Project: RU-26-00001 Pazaruski
BPA Line Name: Rocky Reach-Maple Valley No 1
ADNO: 6466
Location: NW $\frac{1}{4}$ of S. 15, T 22N, R. 11E, Kittitas County, WA

Subject: BPA Response to Pazaruski Reasonable Use Request

To: All Staff
From: Environmental Health
Date: April 22, 2026
Subject: RU-26-00001 Pazaruski

SUBJECT: WDFW COMMENTS ON RU-26-00001 Pazaruski

LOT 9 HYAK ESTATES 2 GRADING DESIGN
RYAN PAZARUSKI
SITE PLAN

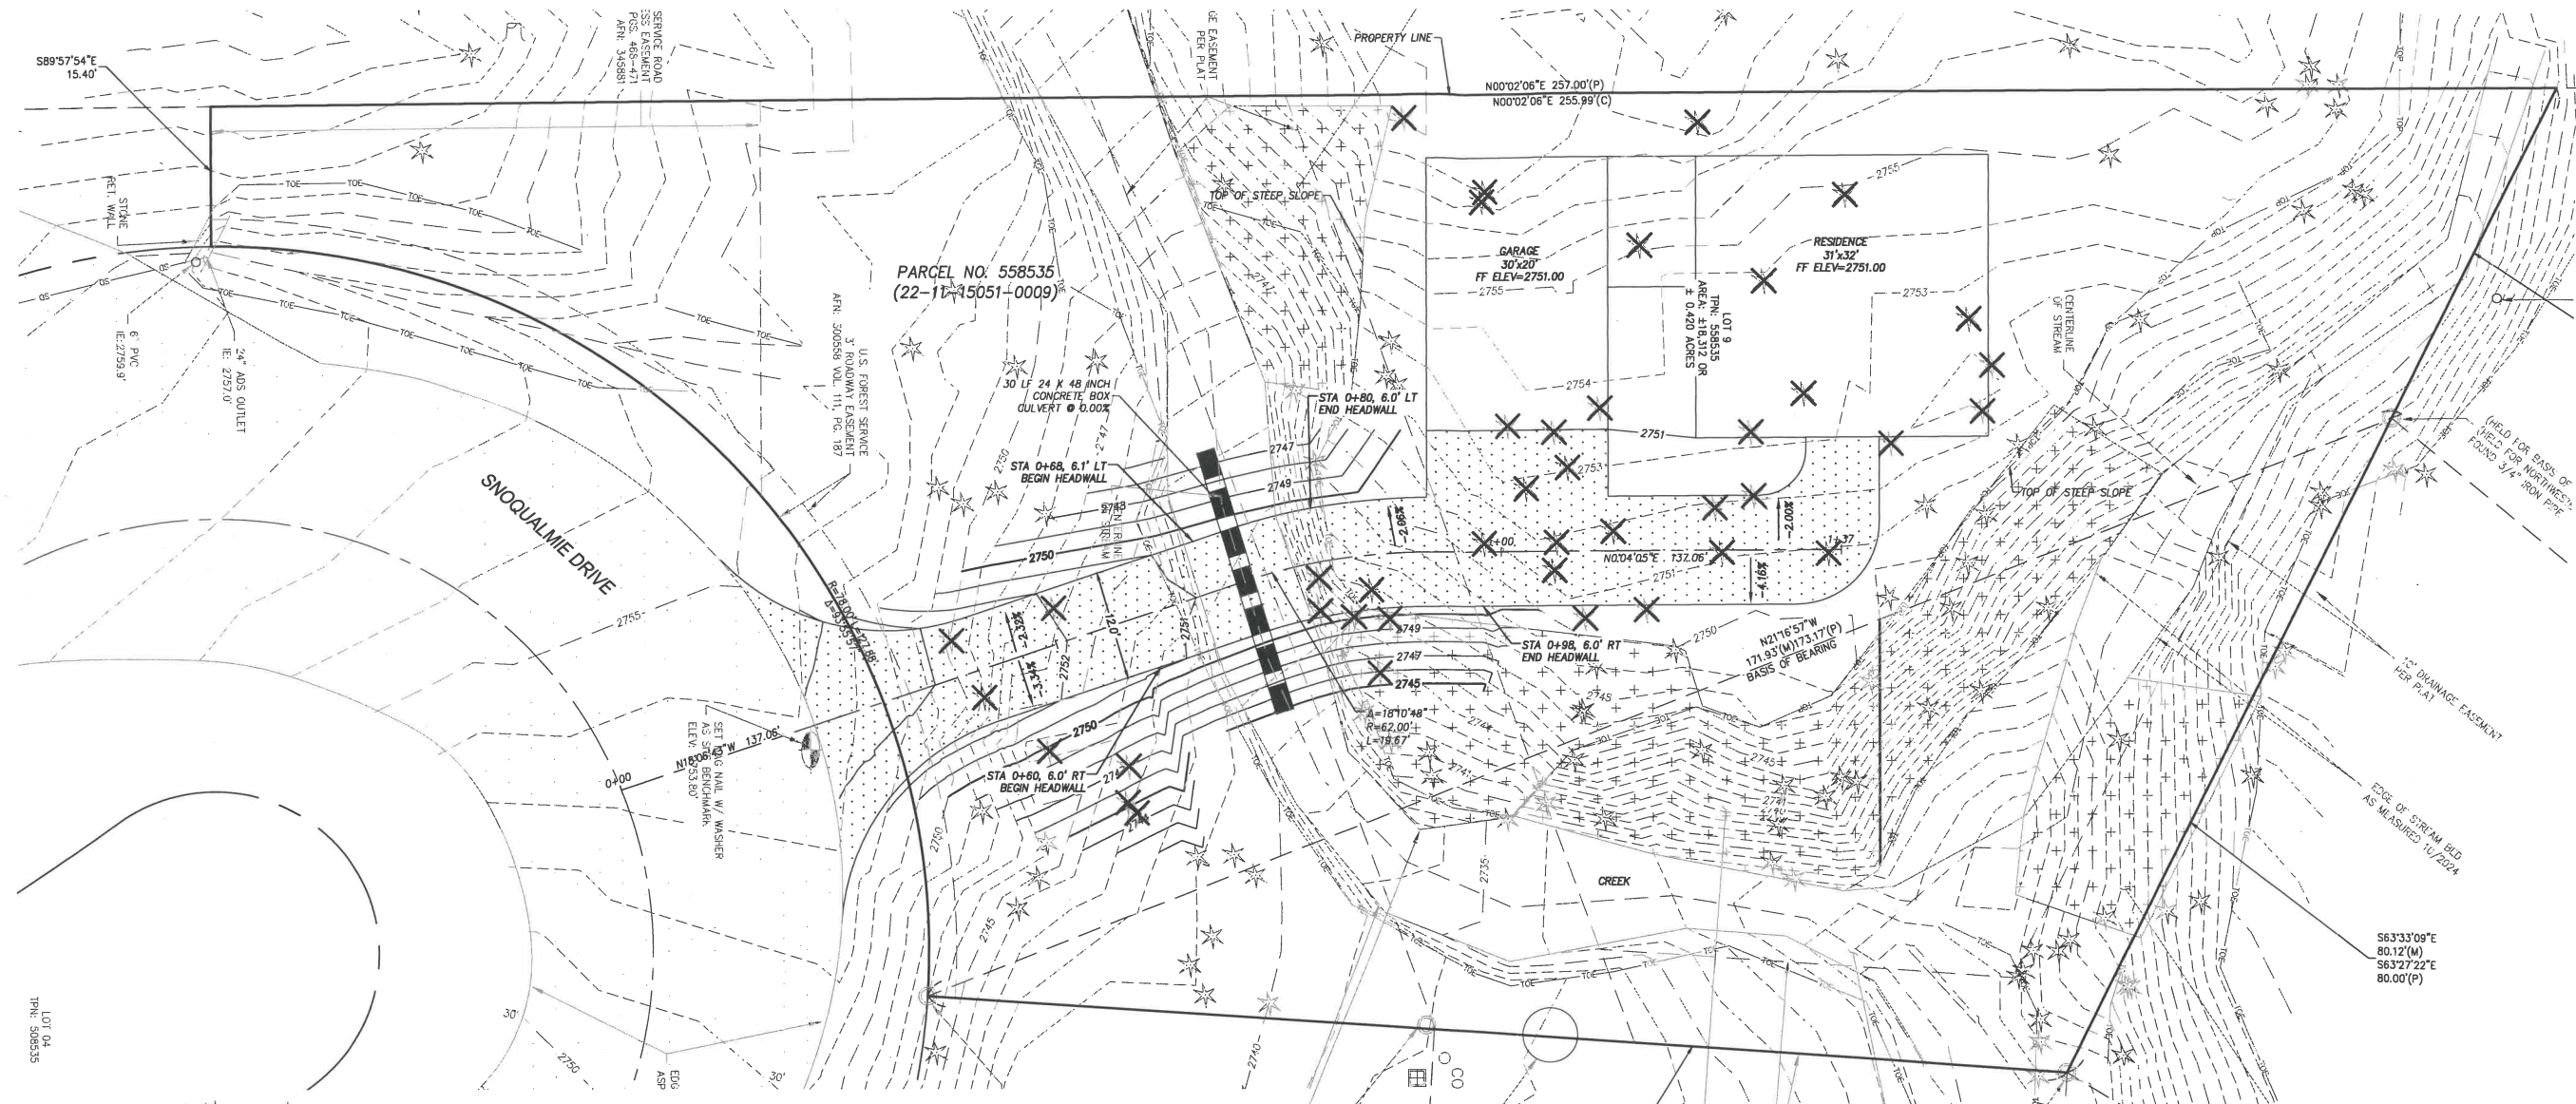
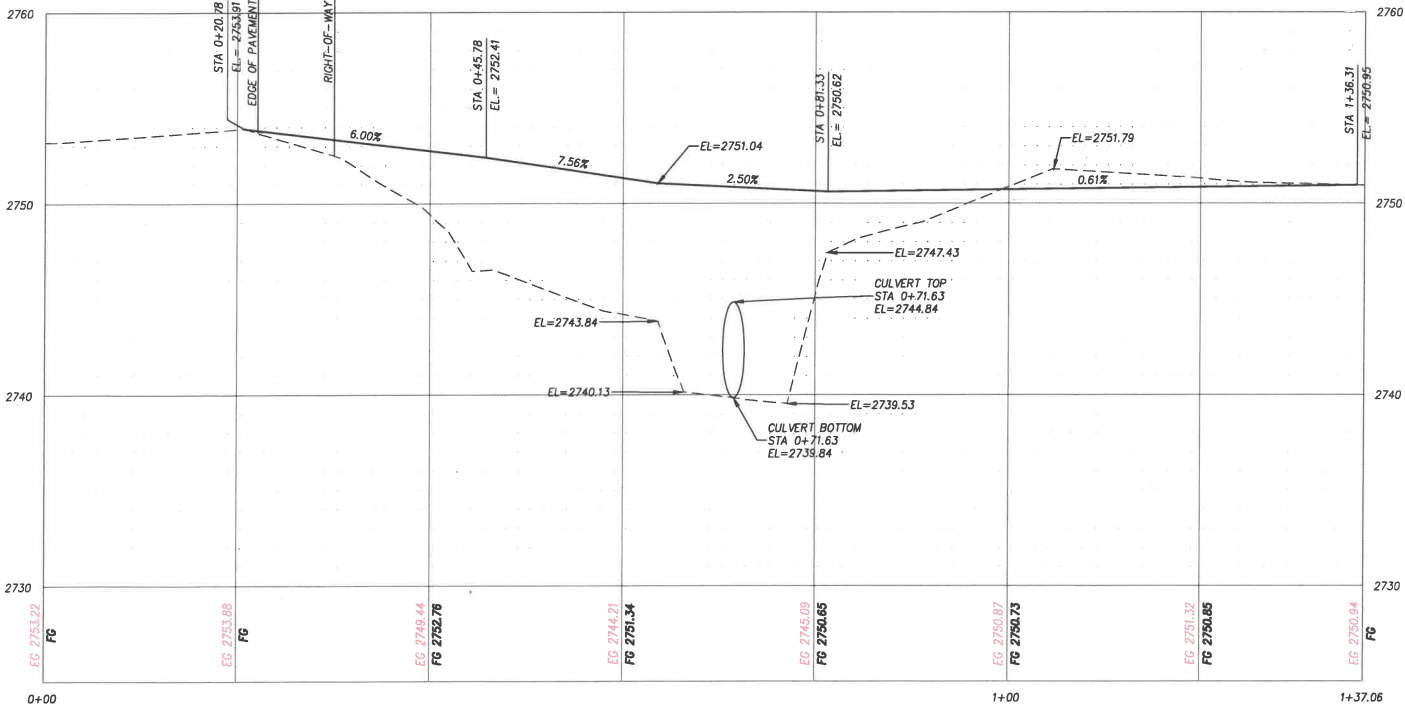
SURVEY	Site plan does not meet the new requirements of WAC 332-130-145. (JT)
TRANSPORTATION CONCURRENCY	No comment.

My concern would be the flow path of the stream, and whether the culvert is sized to prevent any change in that path.

- The plans the HPOA received have a garage footprint of 31' by 32'. Site plans submitted to us and the county show a site plan with a garage of 20' by 30'. We were told changes were still being made but we have to go off information provided. These differences must be addressed prior to any approval.

RE: Culvert - Nowhere in the documentation that I have been able to find, are any indications of the size of this culvert. It is only mentioned that "The proposed culvert crossing will be designed and installed in accordance with applicable engineering and environmental standards to ensure proper drainage and maintain stream function." (as stated on the Pazarusk narrative owner statement).

5. Culvert Design - there is insufficient information provided regarding the design of the proposed culverts. In the documents provided to the county and to the Hyak Property Owners Association, there is very little information provided and only so much as to say it will follow other culverts in the neighborhood. This design plan is not enough. The amount of water that flows through the streams on the property during the fall and spring seasons is substantial and even heavier during rain and flooding events like this past year. To simply plan on building something similar to another part of the neighborhood is irresponsible. **These statements are concerning**.
